PLANNING CONSULTATION RESPONSE

Application No	2025/0127
Proposal	(AMENDED PLANS, RED LINE BOUNDARY AND DESCRIPTION) Residential development for 32 dwellings with associated landscaping and access.
Address	Land off South View, Darfield, Barnsley, S73 9NA.
Date of Consultation Reply	13/02/26
Consultee	Nik King, Senior Urban Design Officer

These are the 3rd set of design comments on planning application 2025/0127. These are made in the light of the amended plans received 09/12/25.

TYPE B

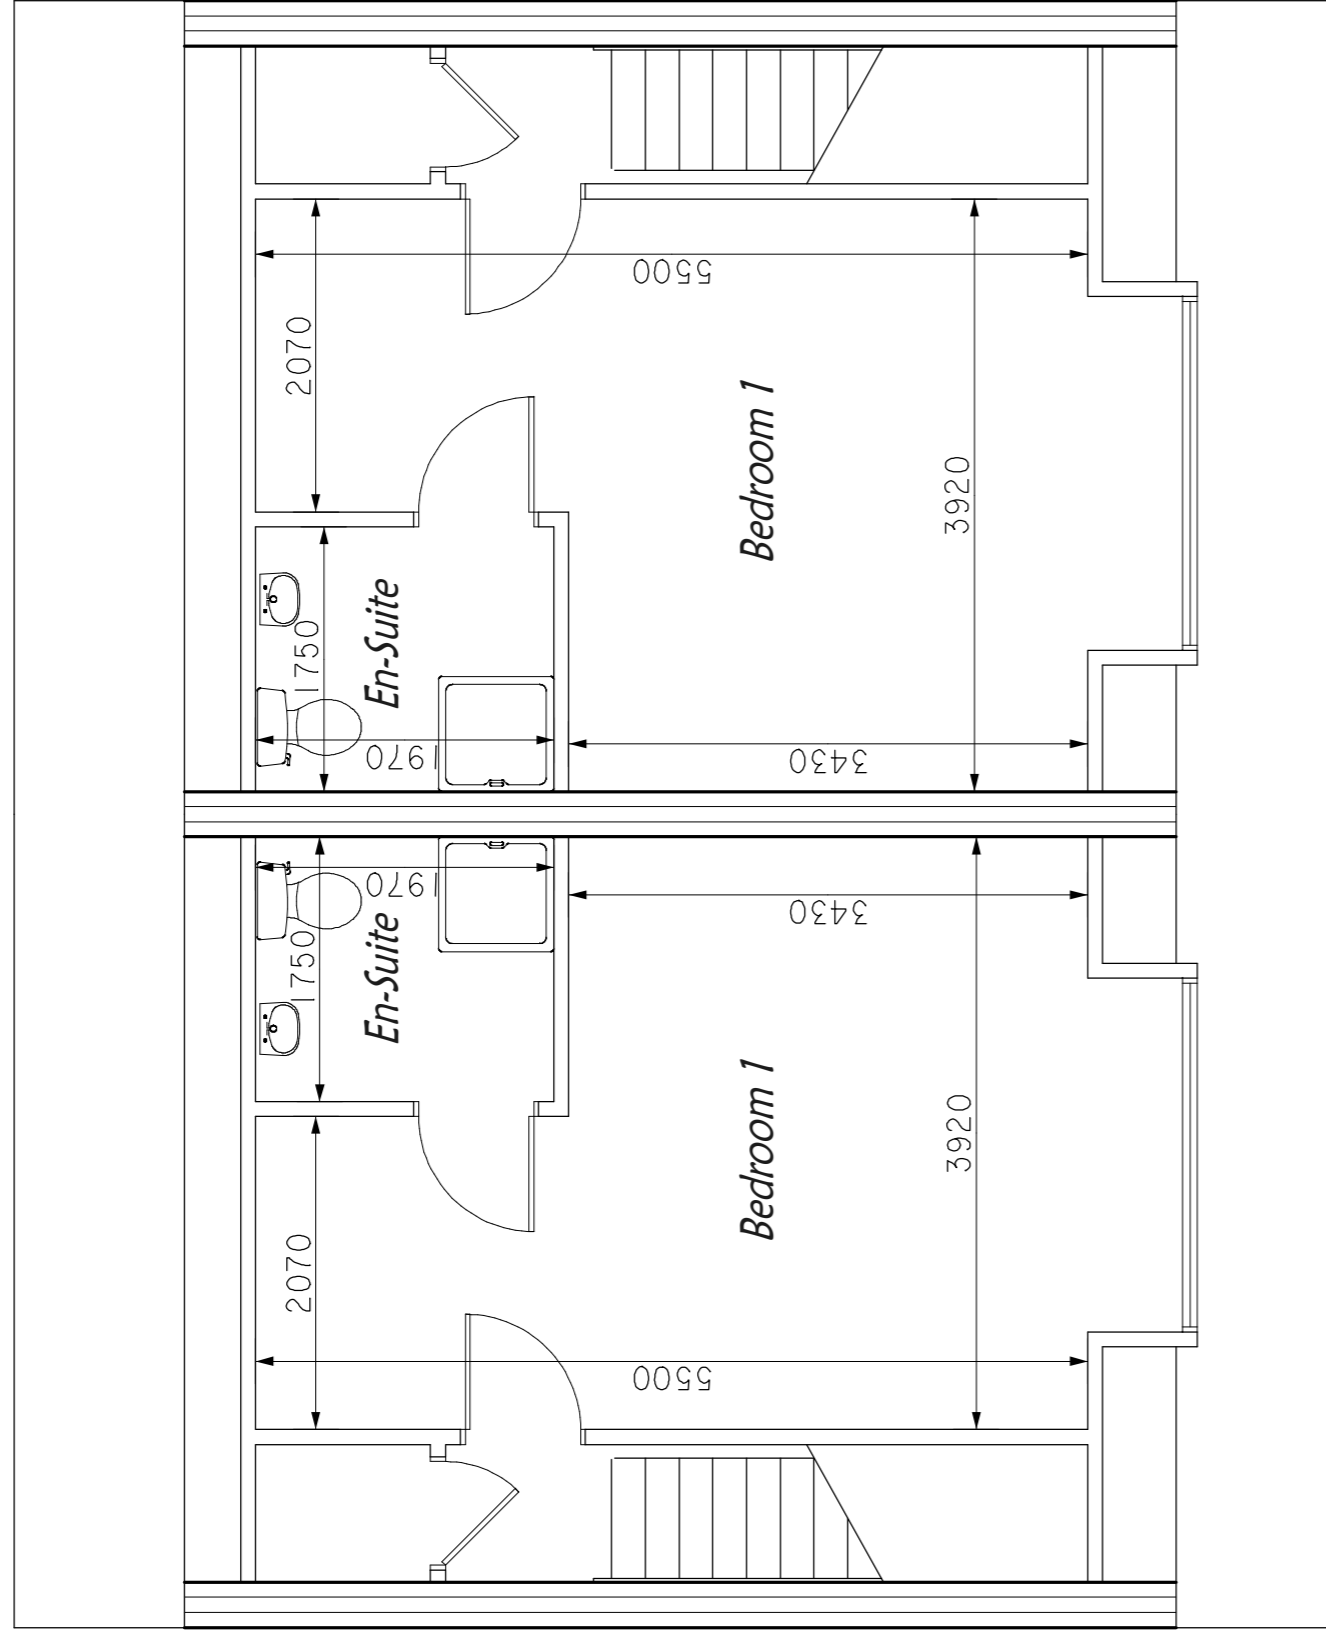
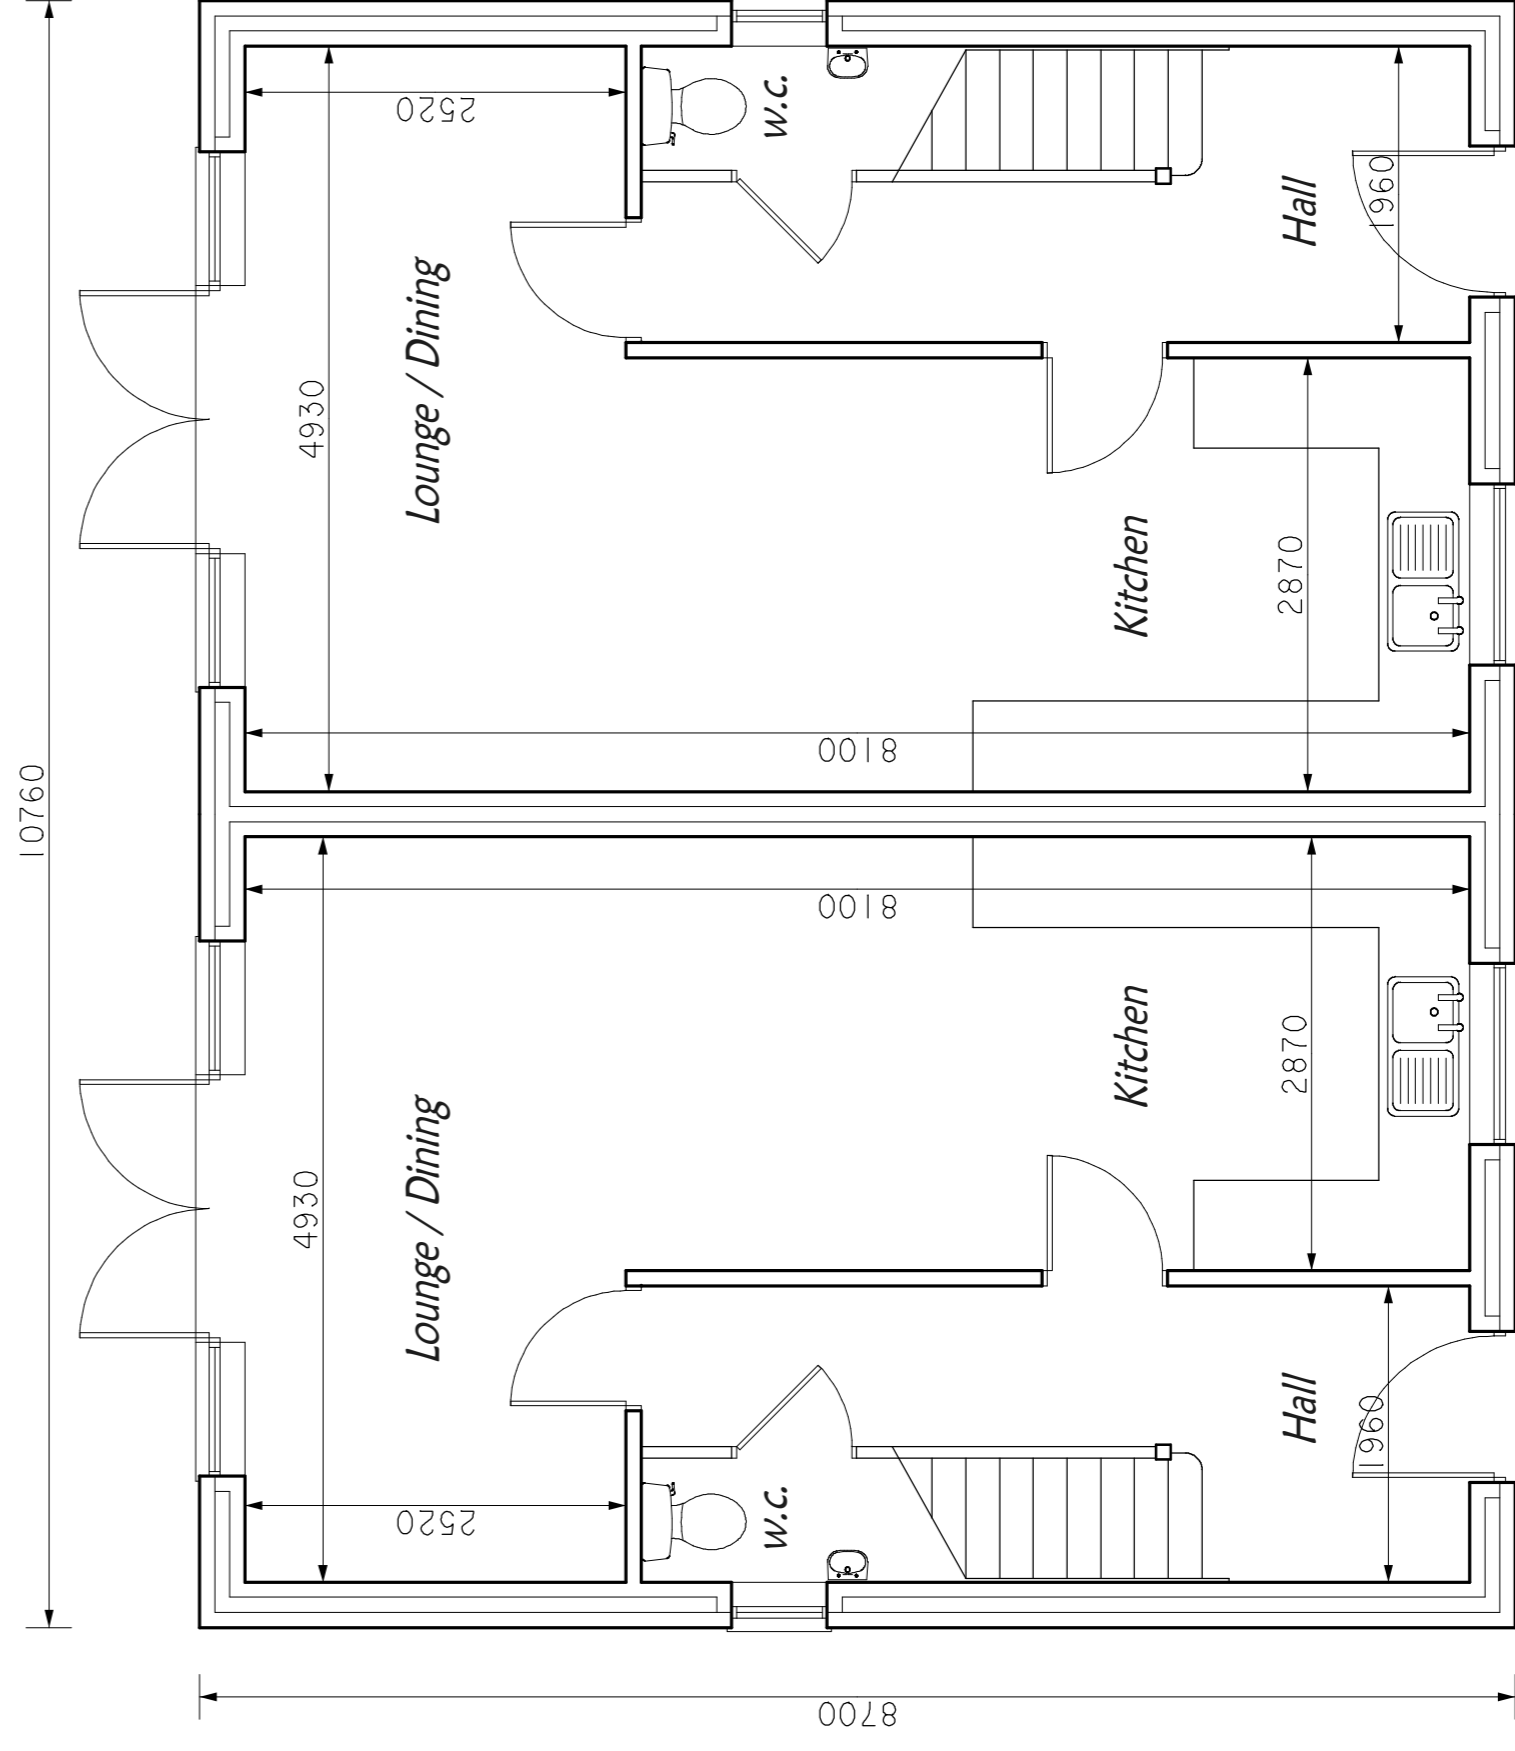
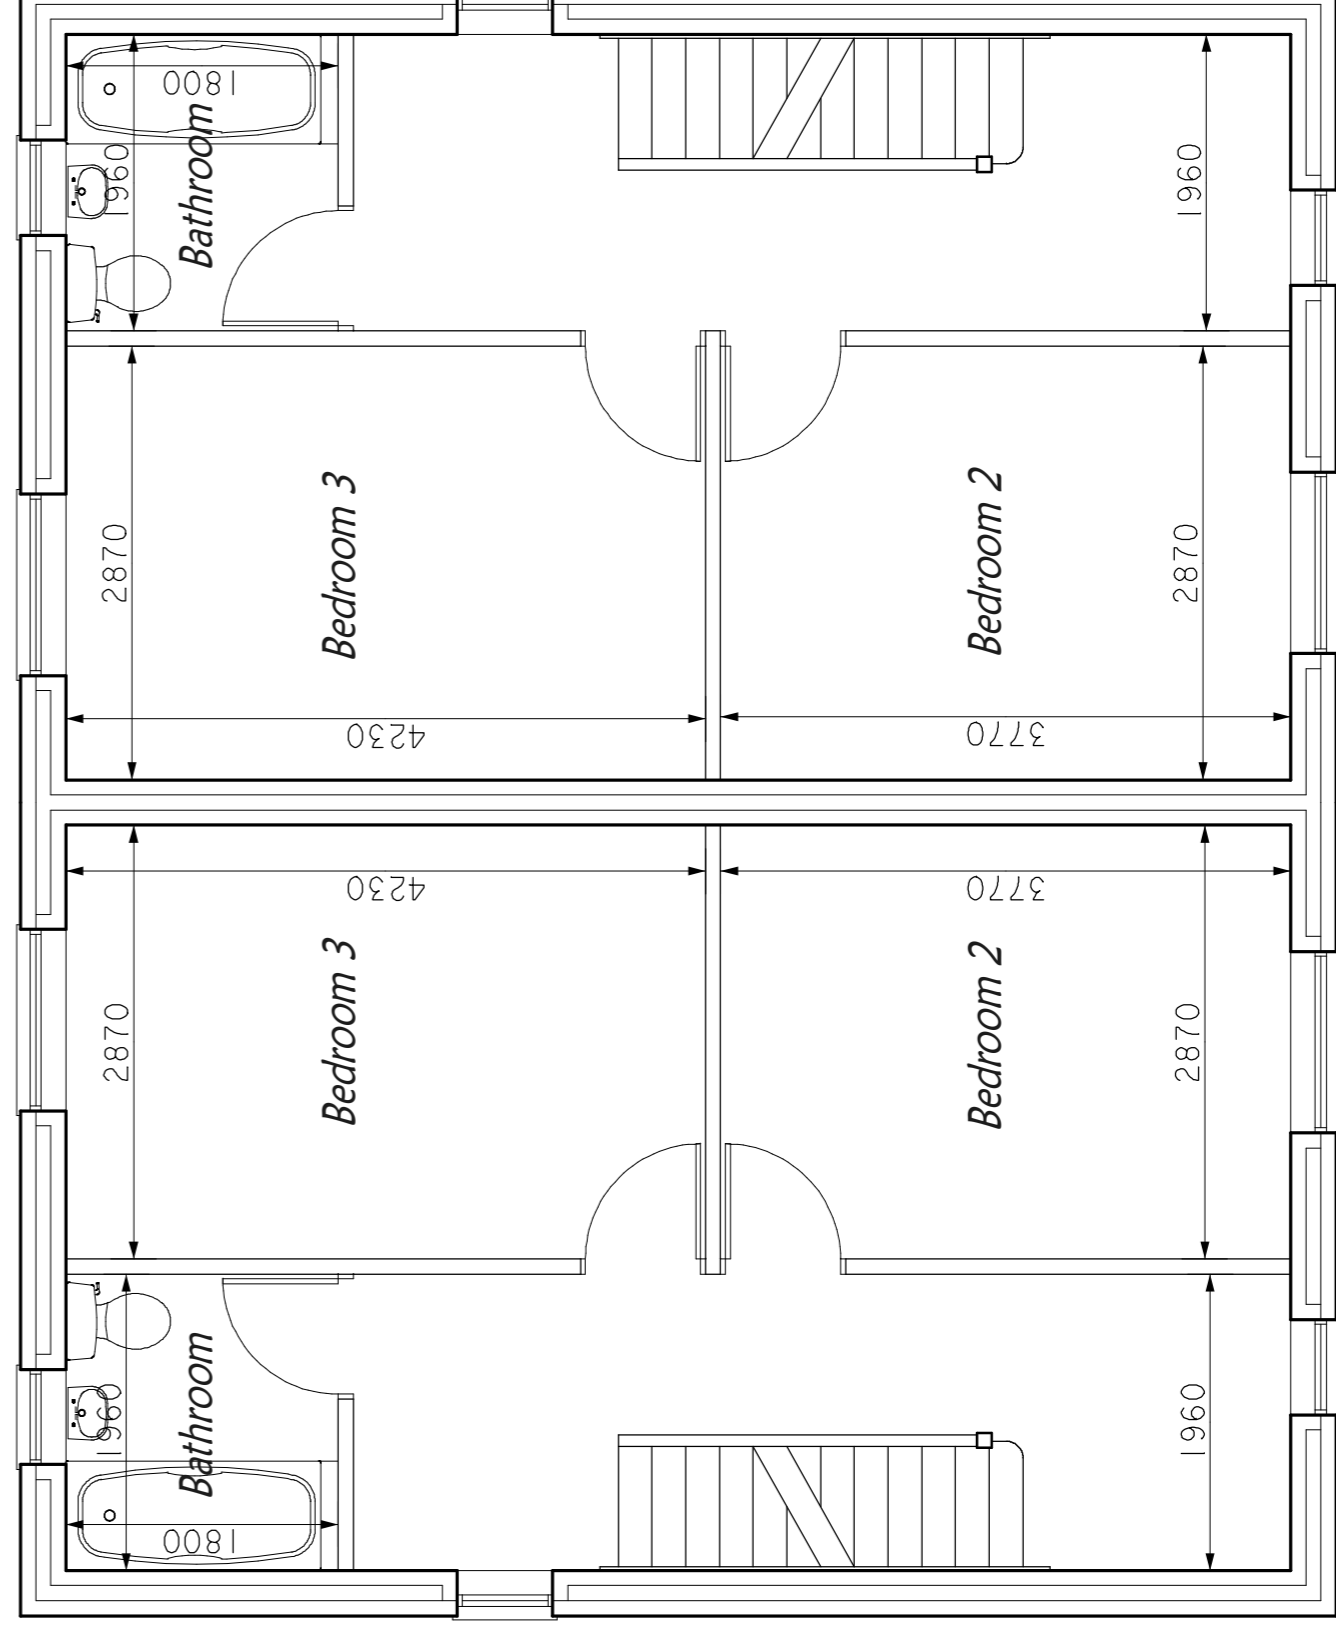
- Poor quality front outlook for some properties
- Rear garden sizes of several plots are undersized.
- Depth of rear gardens are undersized on some plots.
- Internal spacing standard of house type B.
- Accessibility standards for dwellings not met.
- No visitor parking spaces provided.
- Some plots are over dominated by front-of-dwelling parking.
- No street trees in parts of the site

I note that three storey dwellings are now proposed on several plots, with kitchen/dining/living rooms on the first floor and juliet balconies. The roof heights have been increased from two and a half storeys to 3 storeys. However, there are no changes to the number or location of proposed dwellings. I just feel that this rather 'hems in' the development and causes overlooking issues.

I would suggest that all dwellings are either 2 storeys or 2 and a half storeys and that kitchens and living rooms are located on the ground floor of properties.
